**SMELKER-HCI**  
7920 INDUSTRY ROAD  
COLORADO SPRINGS, CO 80939  
EL PASO COUNTY, COLORADO

1 of 9  
SITE PLAN

# Site Development Plan\_V1.pdf Markup Summary

SITE PLAN

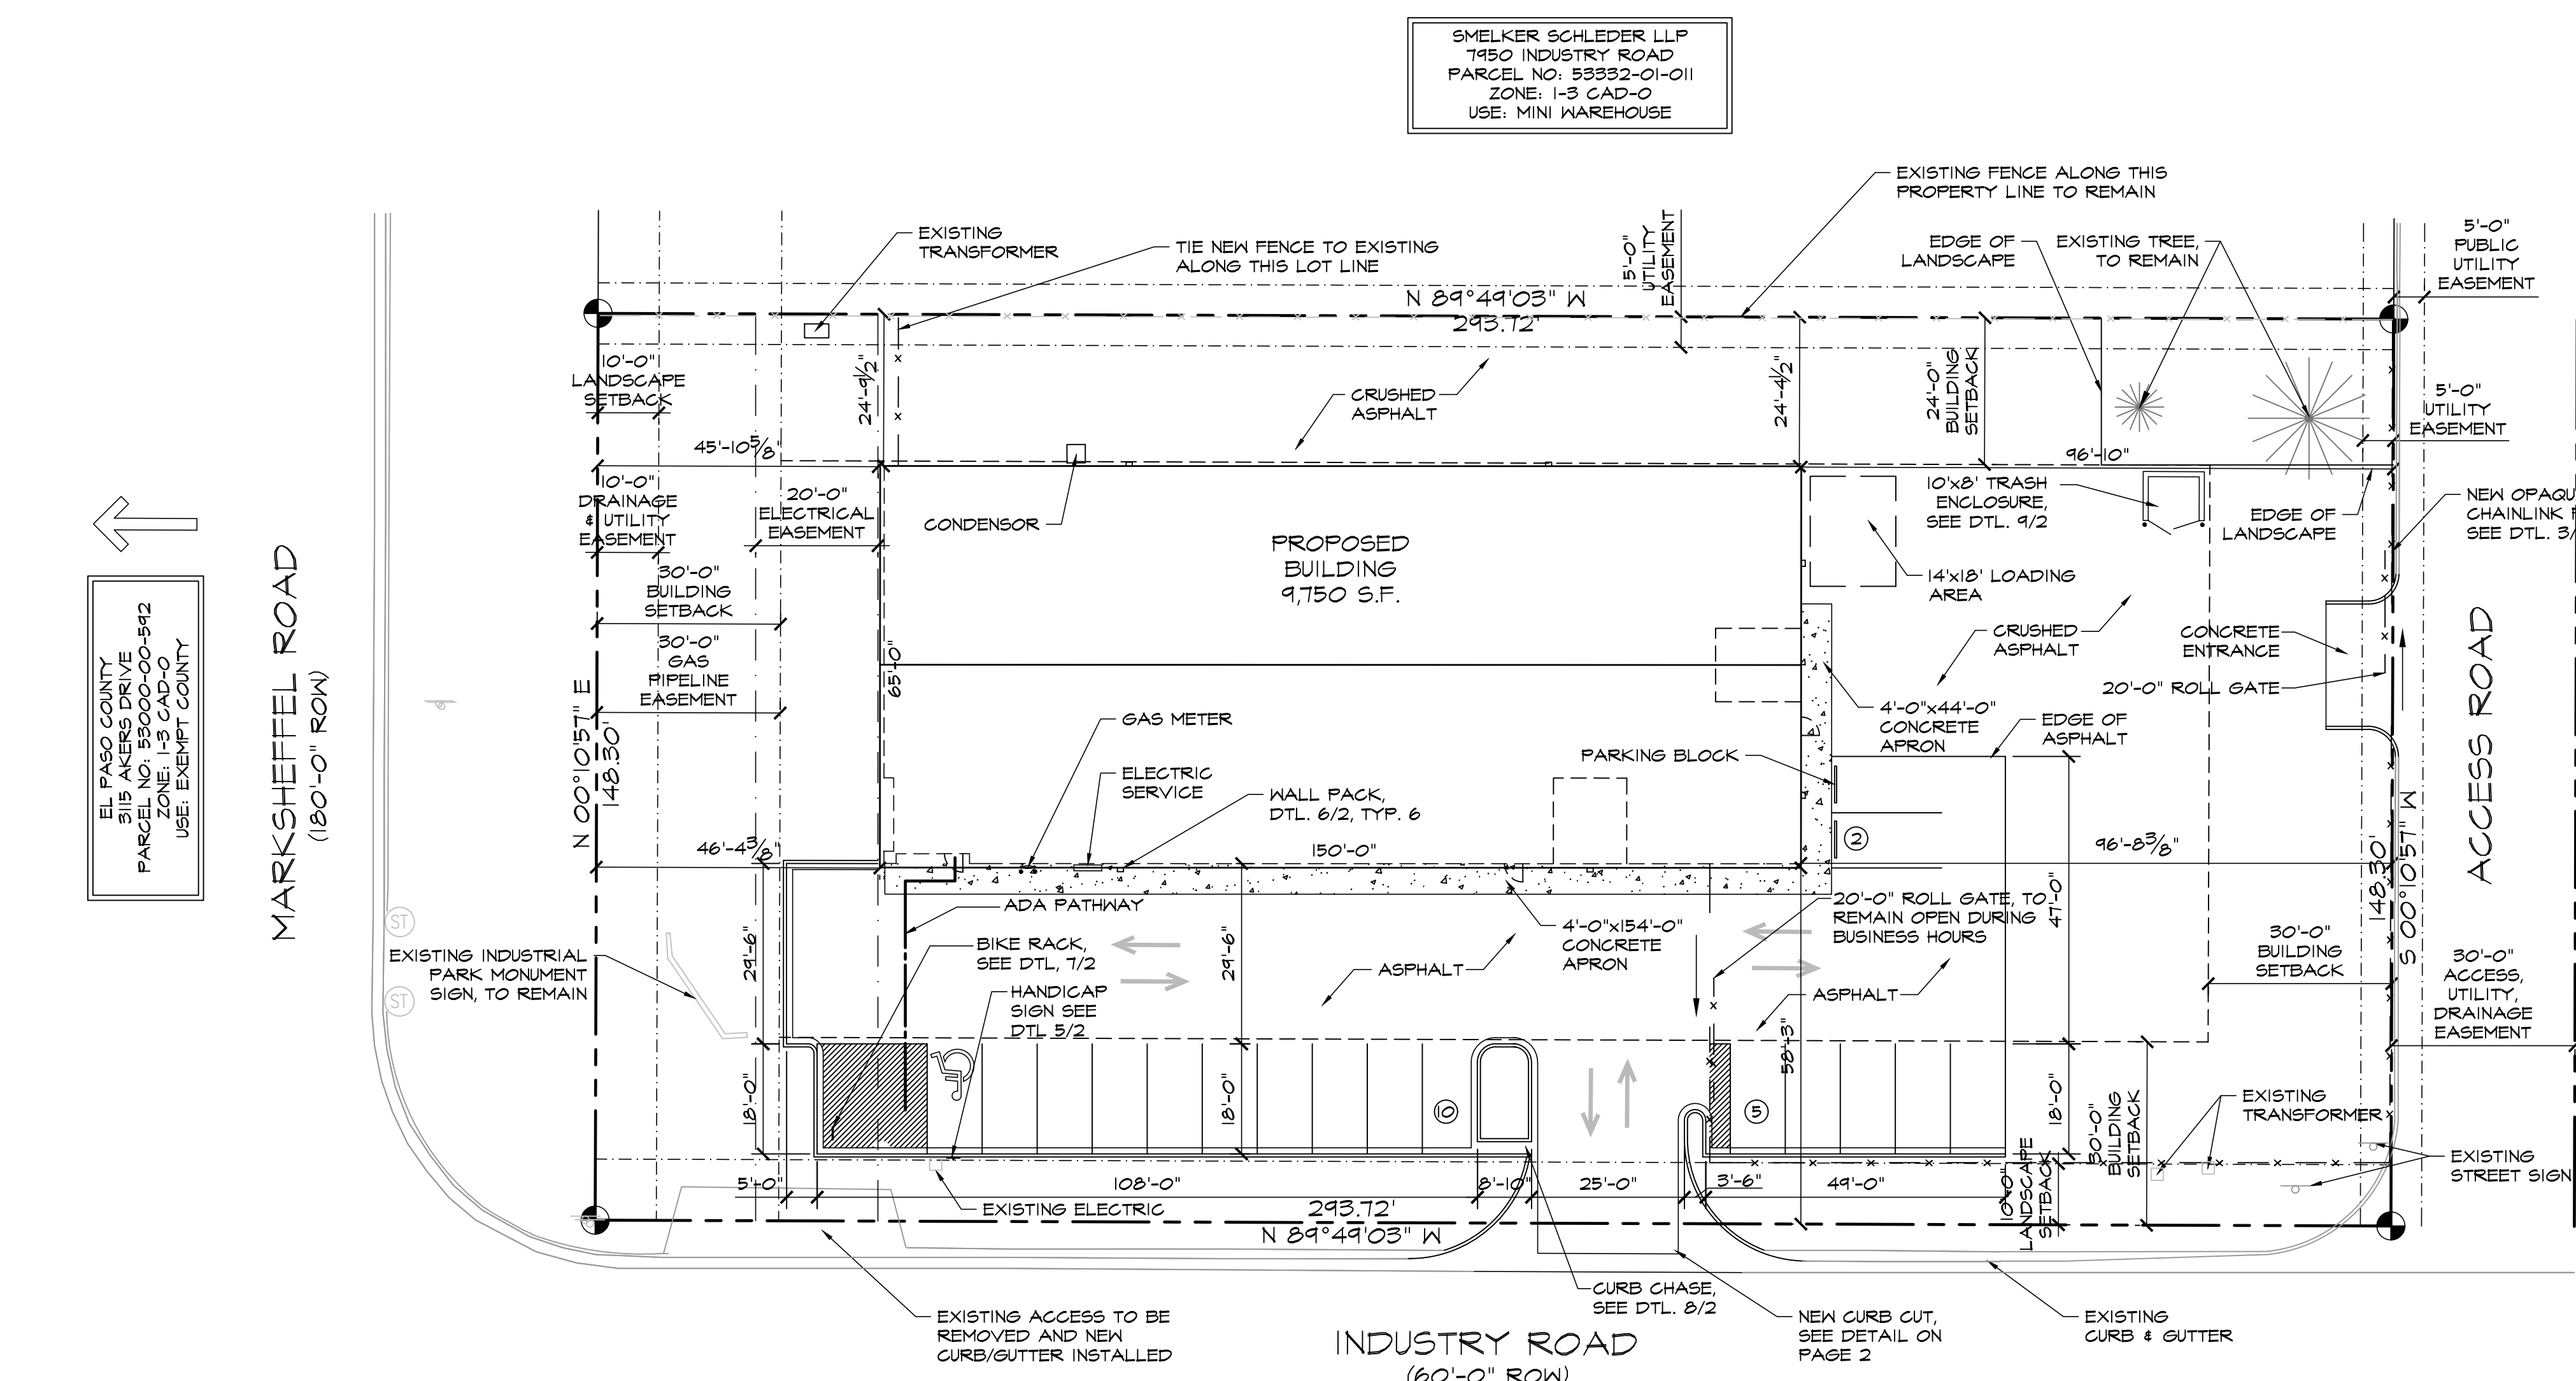
Per SDP Checklist, provide signature block for the Planning and Community Development Director a minimum of 1 inch by 2 inches

Gate Location and Dimensions. Gates shall be located a minimum of 30 feet from the public right-of-way and shall not open outward. The opening provided through a gate shall be 2 feet wider than the traveled way.

Provide curb return detail

Label existing transformer/power utilities

Clarify if any new signs will be proposed

Change to 180ft ROW

Add PCD File # PPR-22-037

Total parking spaces provided shall be 17; 16 standard and 1 ADA space - The count on the site plan is only 15 provided; 1 ADA space provided.

6.2.5. Parking, Loading and Maneuvering Standards  
(D)Parking Space Requirements. (1)Number of Parking Spaces. The number of parking spaces required is equal to the total number of standard parking spaces and disabled parking spaces required by this Section.

8/11/11	Typical Cross Plan Layout Detail	EL PASO COUNTY DEPARTMENT OF TRANSPORTATION
DATE APPROVED:	Standard Drawing	
André P. Brackin	FILE NAME: SD_2-26	
DEPARTMENT OF TRANSPORTATION	REVISION DATE: 12/8/15

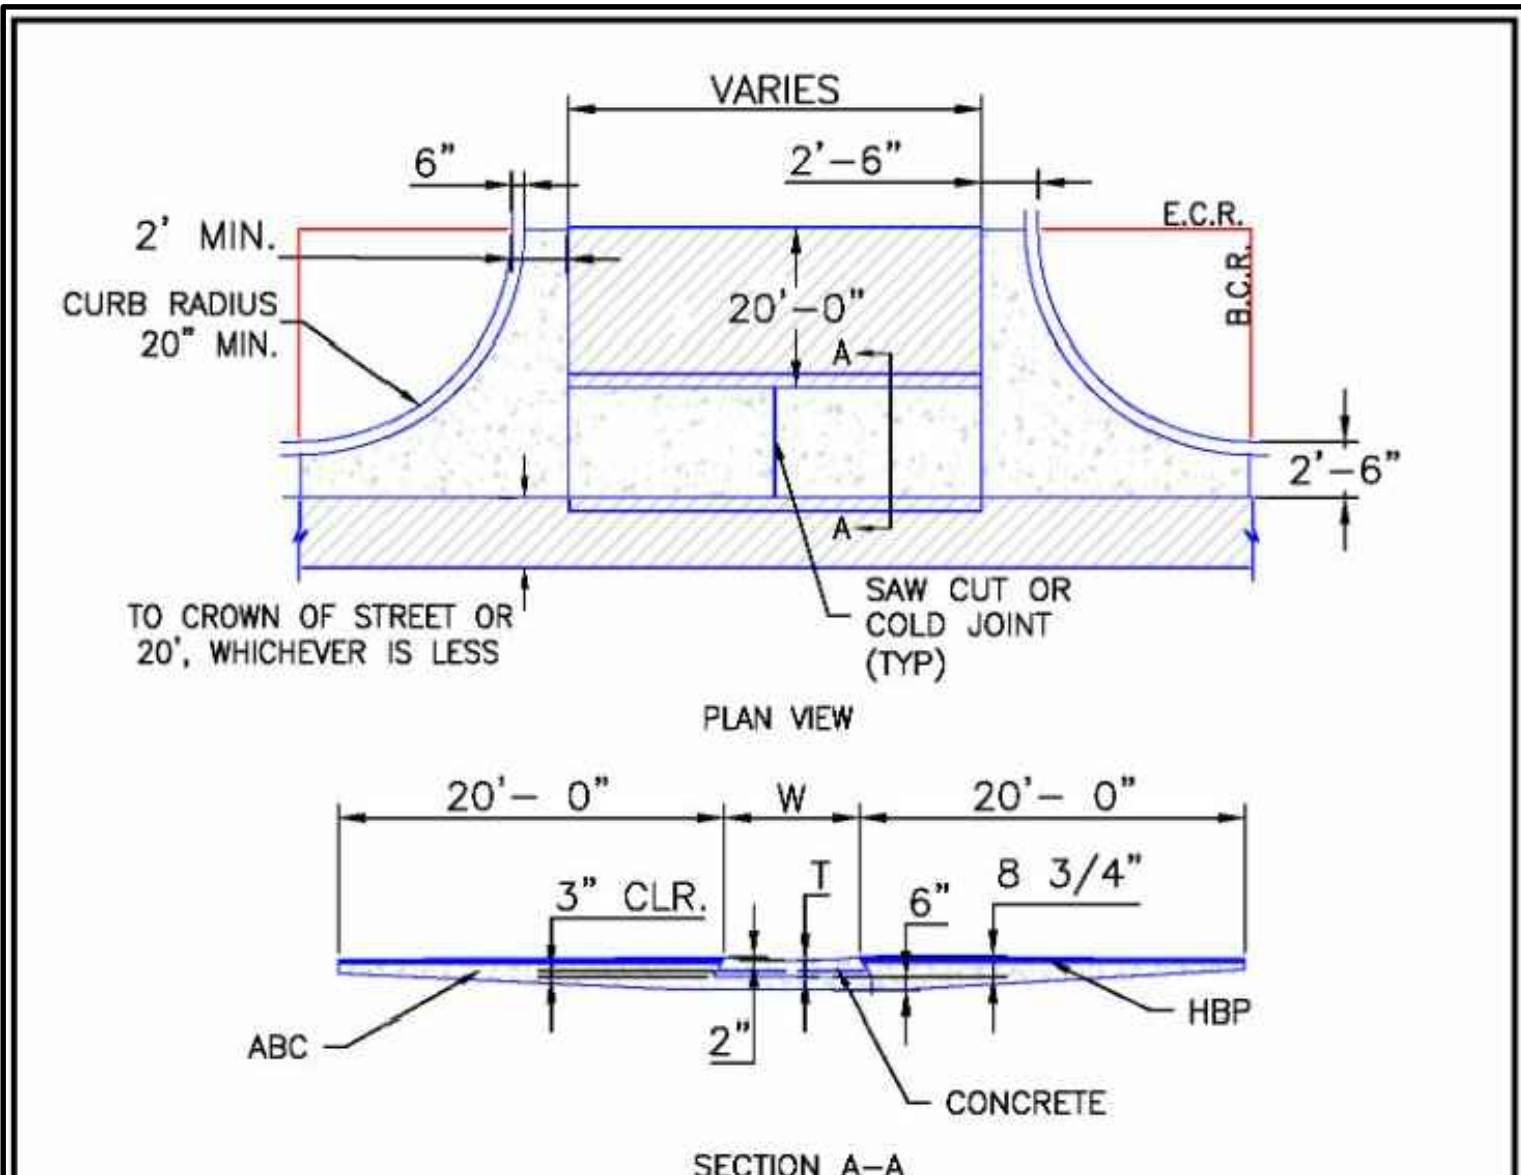
Add Standard Drawing SD\_2-26 Typical Cross Pan Layout Detail.
